**Planning Department
Transportation Development Services Section**

**Re: Uptown Dental Associates, 7101 Prospect Pl. NE
60-Day Temporary Certificate of Occupancy – Transportation
Development
Architect's Stamp dated 2-24-14 (H19-D081)**

SHEET TITLE
SITE PLAN FOR ADMINISTRATIVE AMENDMENT

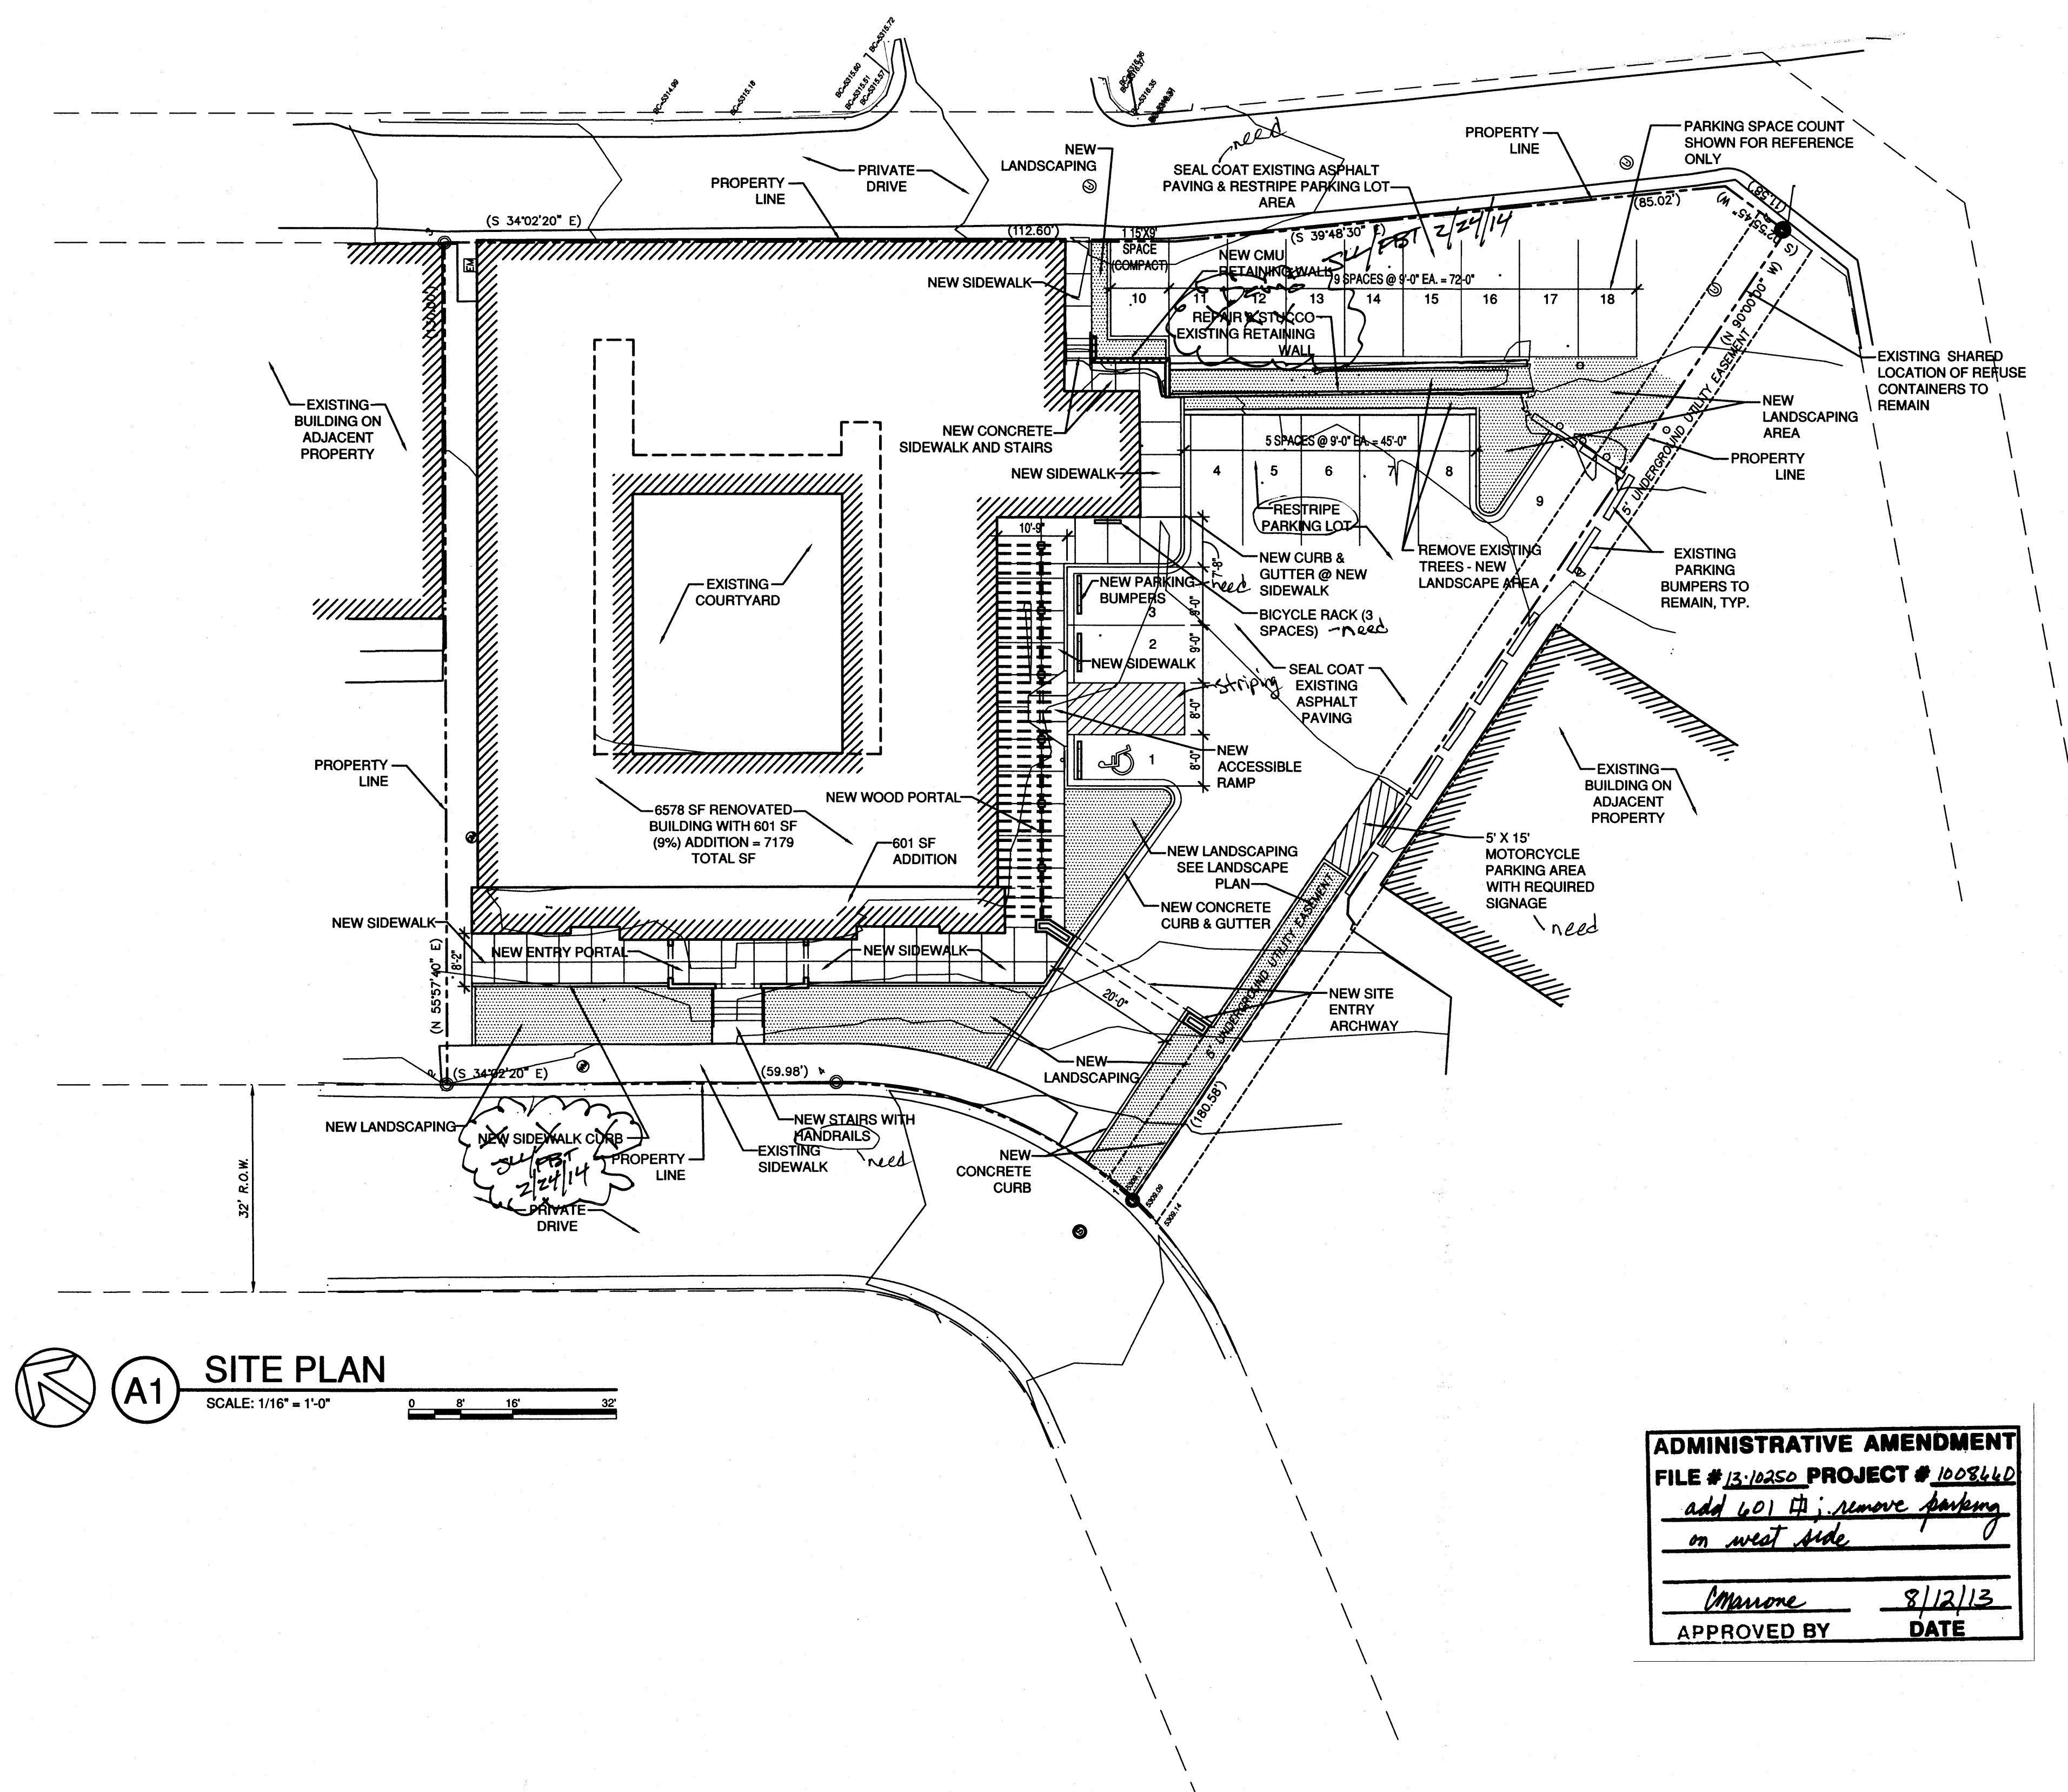
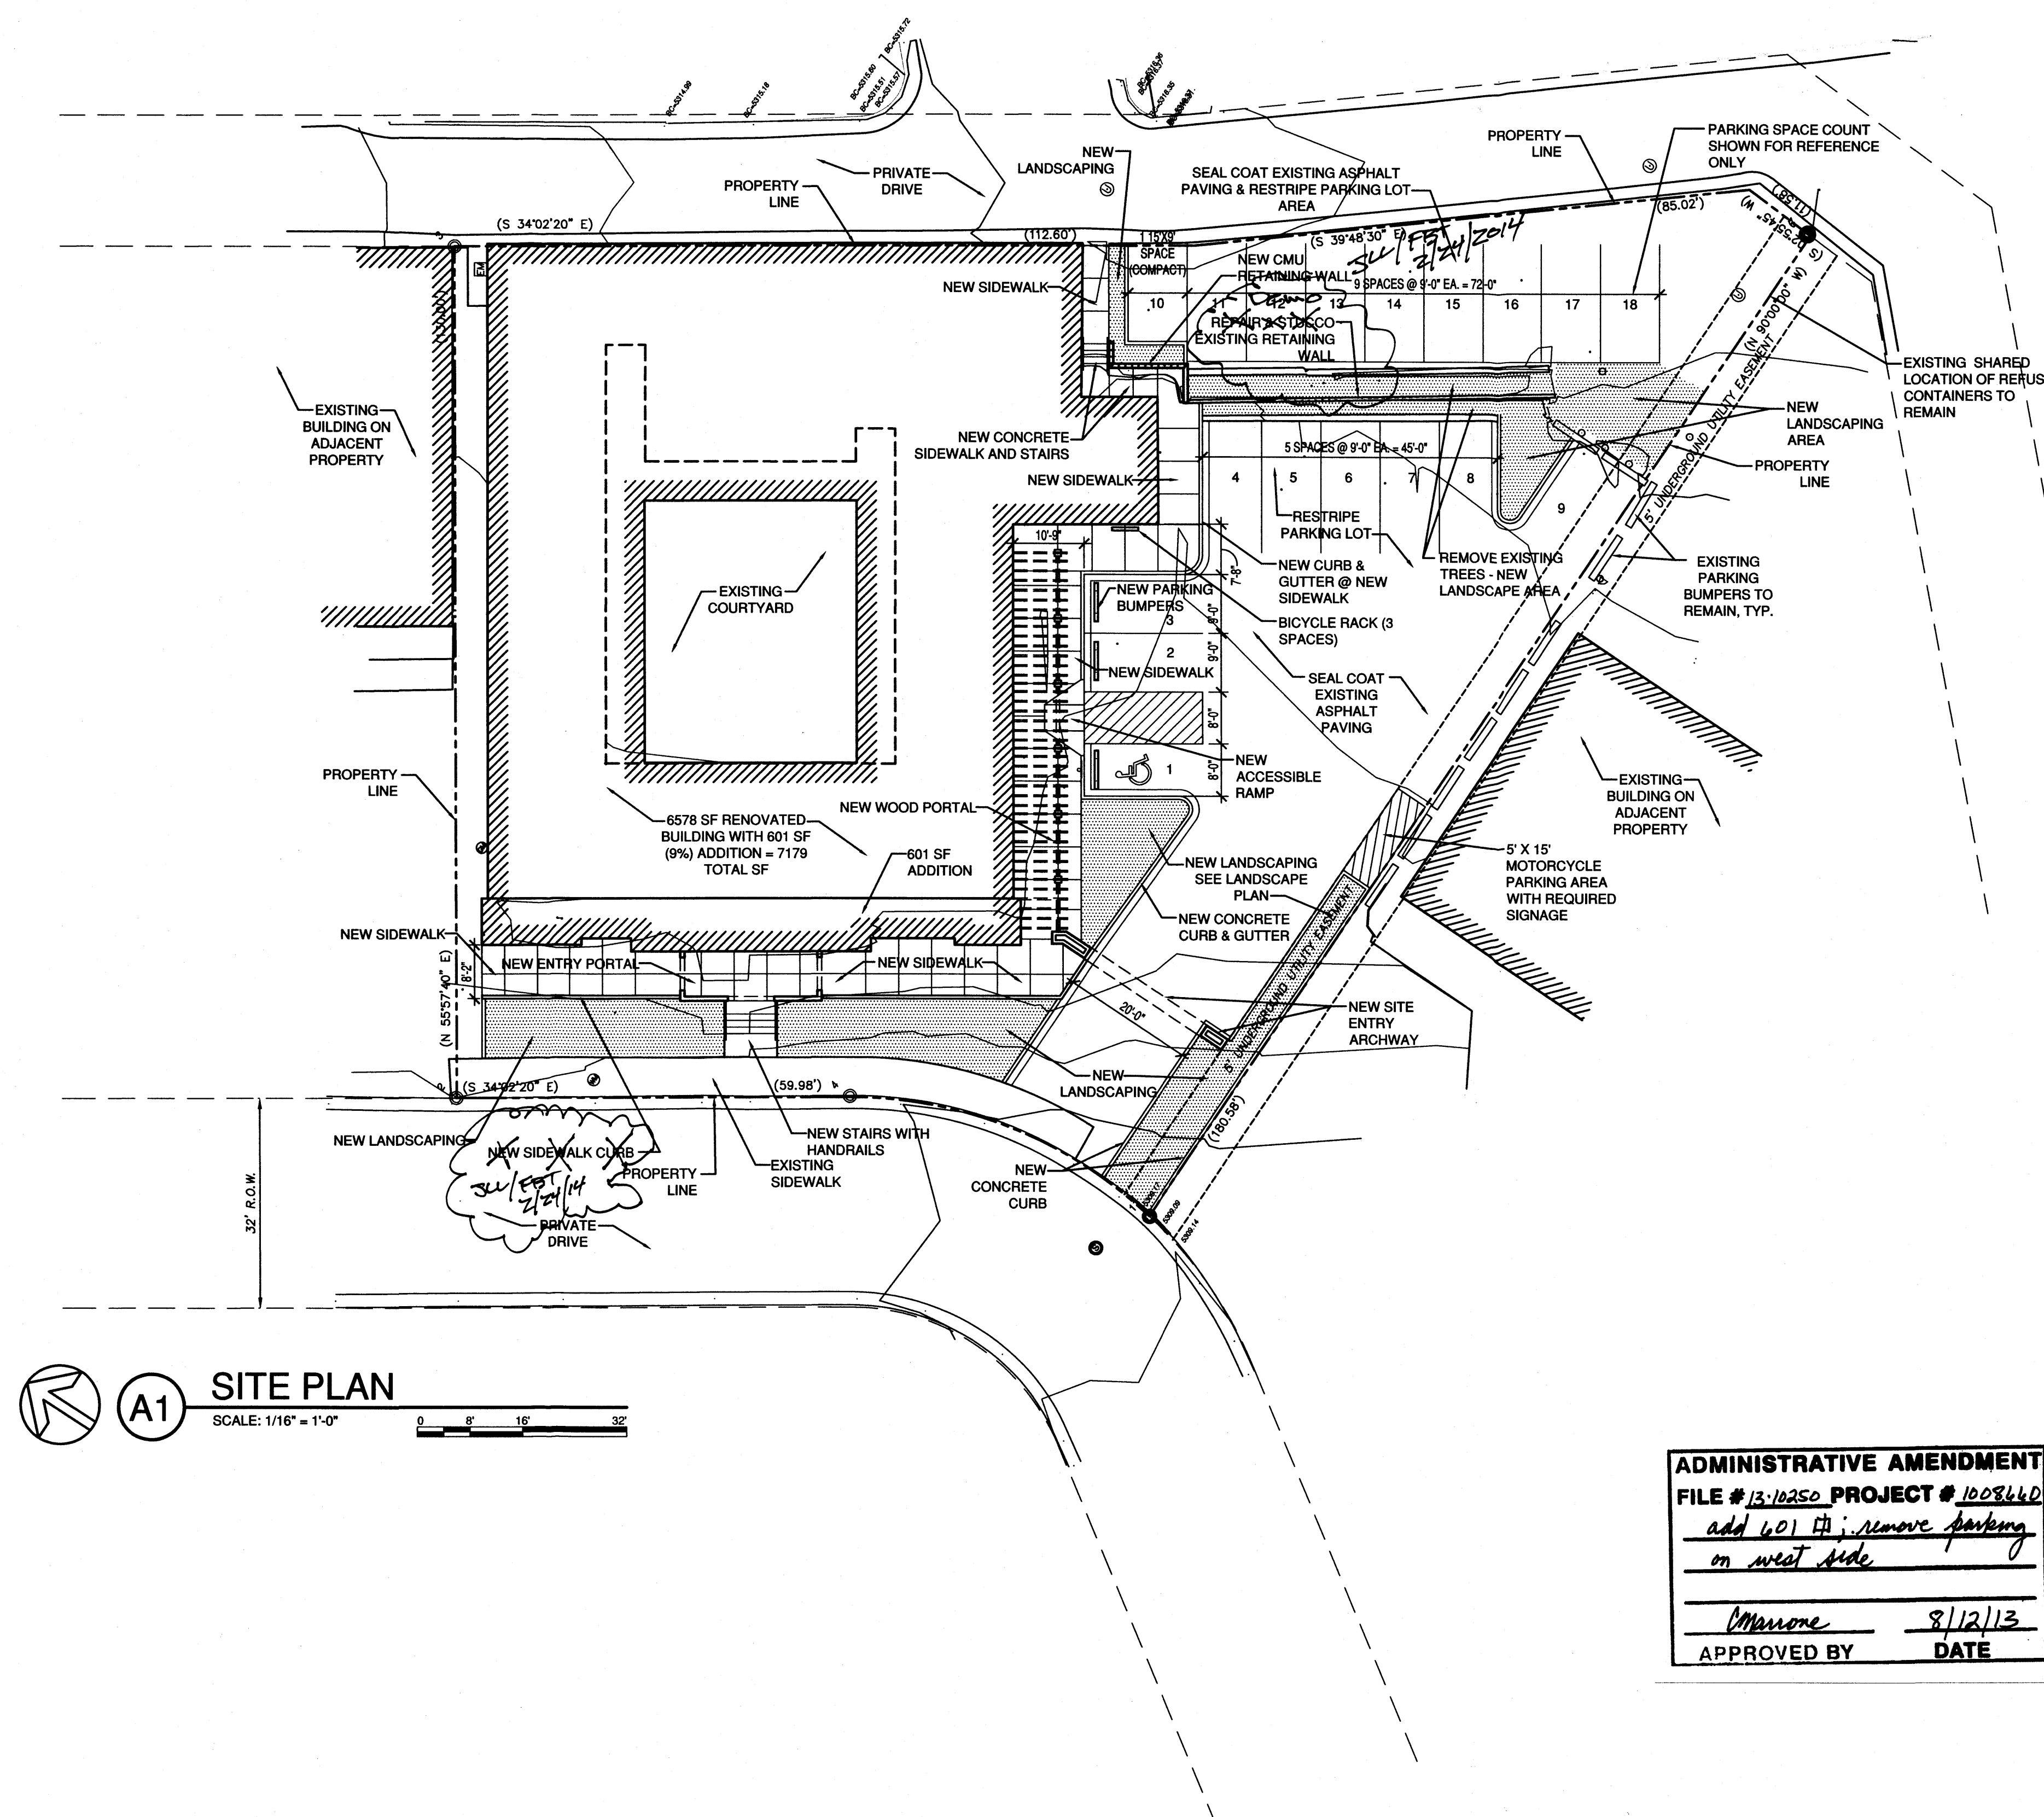
- Sidewalk at front of building needs to be finished, specifically the connection to the adjacent property at the north.
